Application for a non-material amendment following a grant of planning permission.

Single storey rear extension	
Reference number:	BR/82/20/HH
Date of decision	28/05/2020

Change of roof tiles to standing seam zinc roof covering

Drawing P01a March 2020 Scale 1:100 @ A3
Planning Drawing - Floor Plan, Roof Plan and Elevations

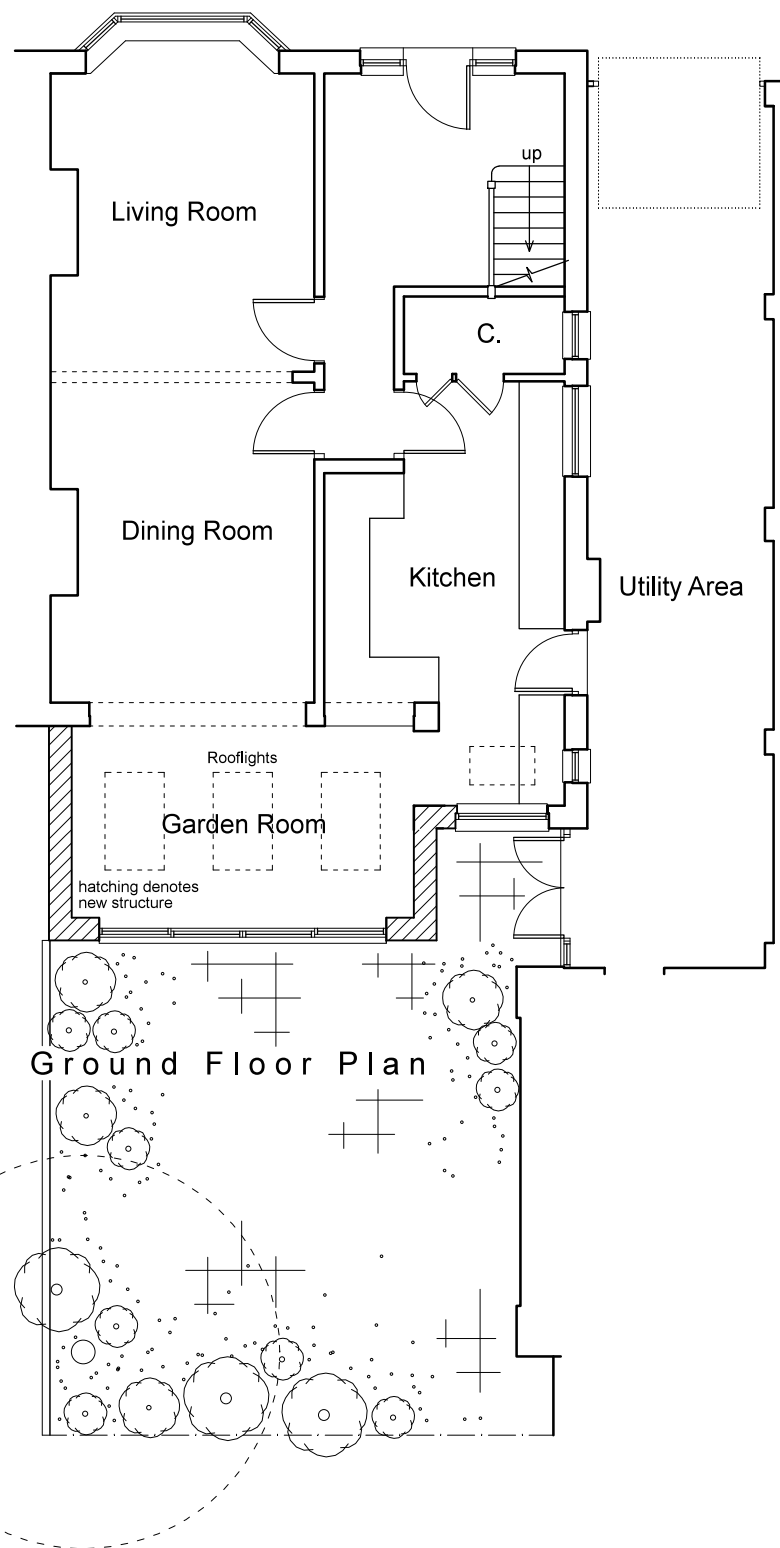
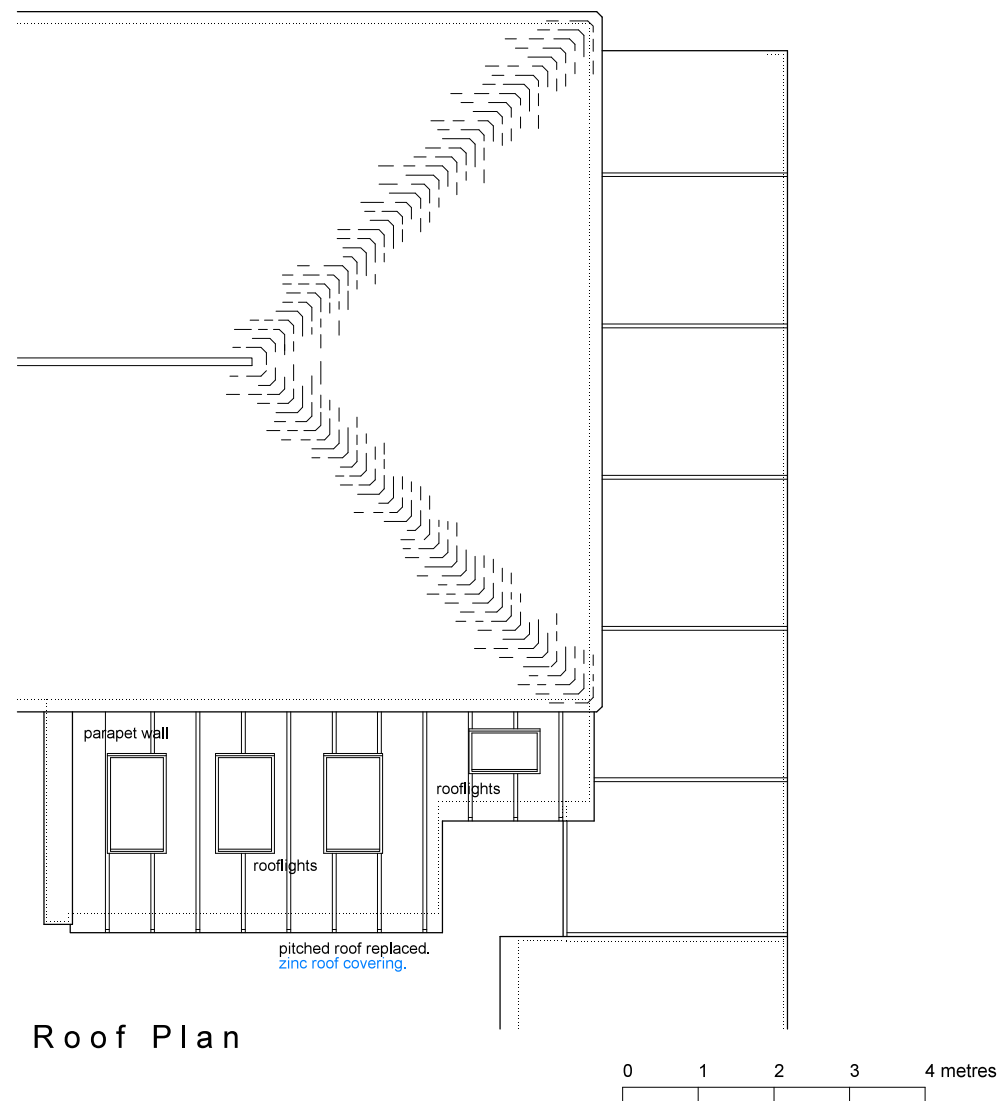
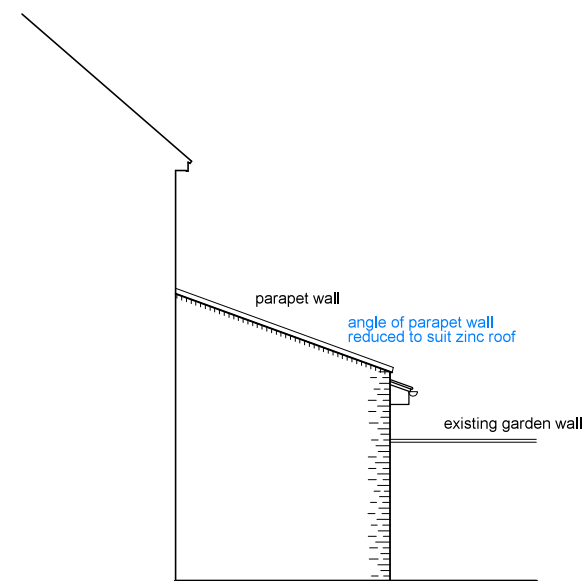
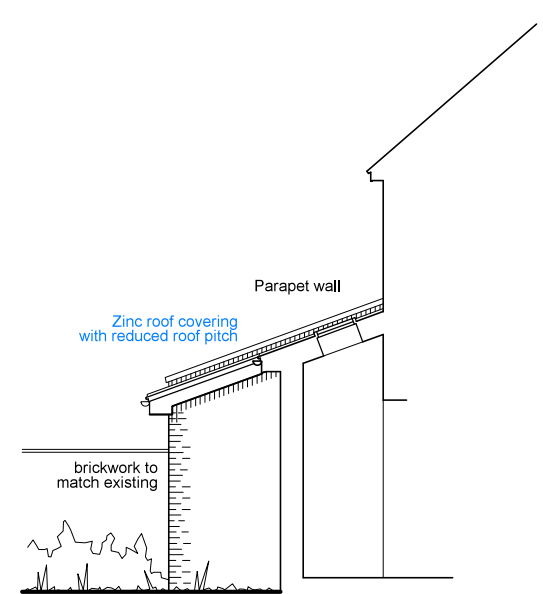
Old plan/drawing numbers

Drawing P01

New plan/drawing numbers

Drawing P01a
